From: planning.comments@york.gov.uk
Subject: FW: 21/02236/NONMAT Application: 21/00834/FUL - 7 Millfield Lane York; Beware of intended breach
Attachments: 2021-01-04 PROPOSED PLAN update.pdf; 2021-01-03 PROPOSED ELEVATION update.pdf

From: j nye <
Sent: 27 October 2021 15:16
To: planning.enquiries@york.gov.uk; Edwards, Paul <Paul.Edwards@york.gov.uk>; Jim Nye
Subject: 21/02236/NONMAT Application: 21/00834/FUL - 7 Millfield Lane York; Beware of intended breach

DRAWING NUMBER
 2021 / 01 / 03 / AMENDED

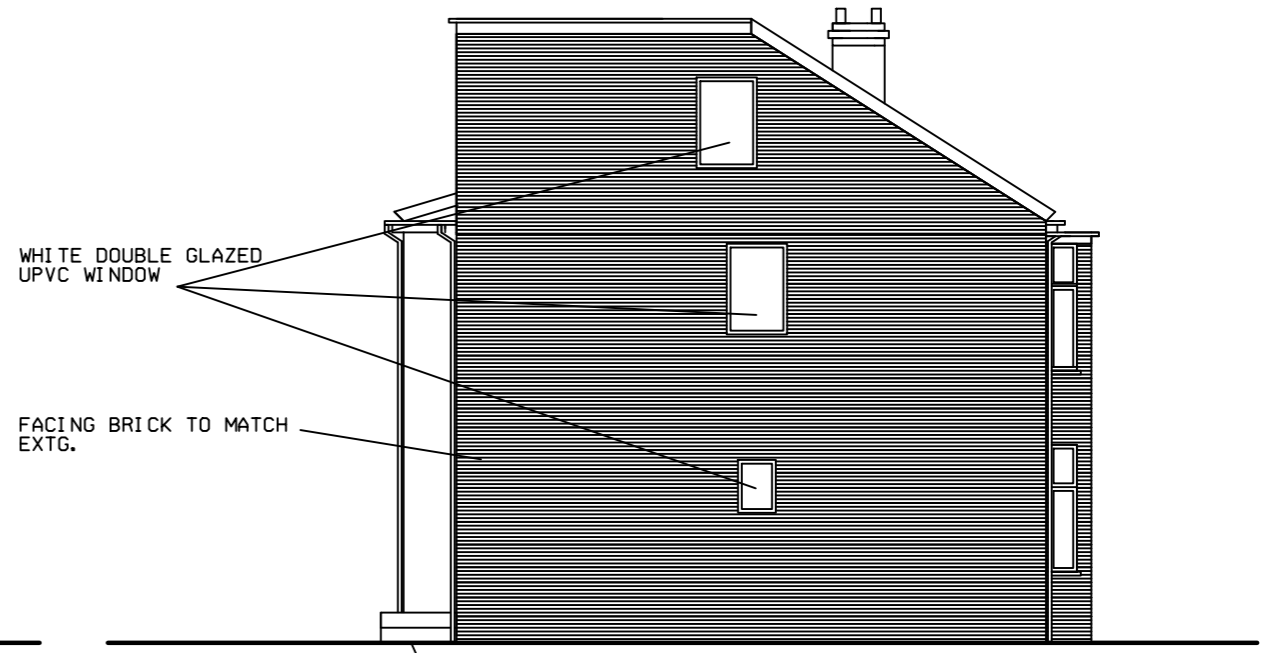
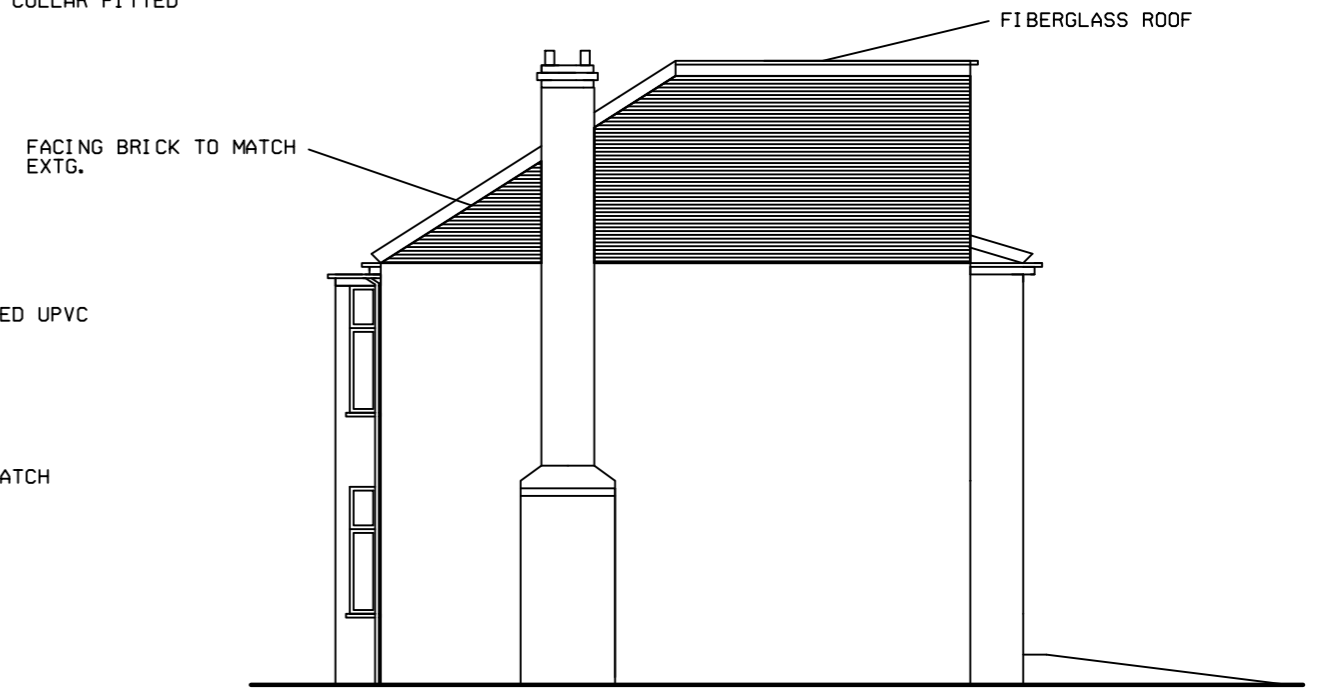
However be aware that the neighbour has subsequently shared a further amendment to his plans that we must object to. These involve a full with and full height dormer style 2nd floor:

- 1) There will be overshadowing issues
- 2) The amenity loss on overlooking would be further reduced
- 3) The extension would be overbearing on the amenity of our garden
- 4) The street scene character will be effected negatively and this property has a dominant aspect being its end and corner to Park position
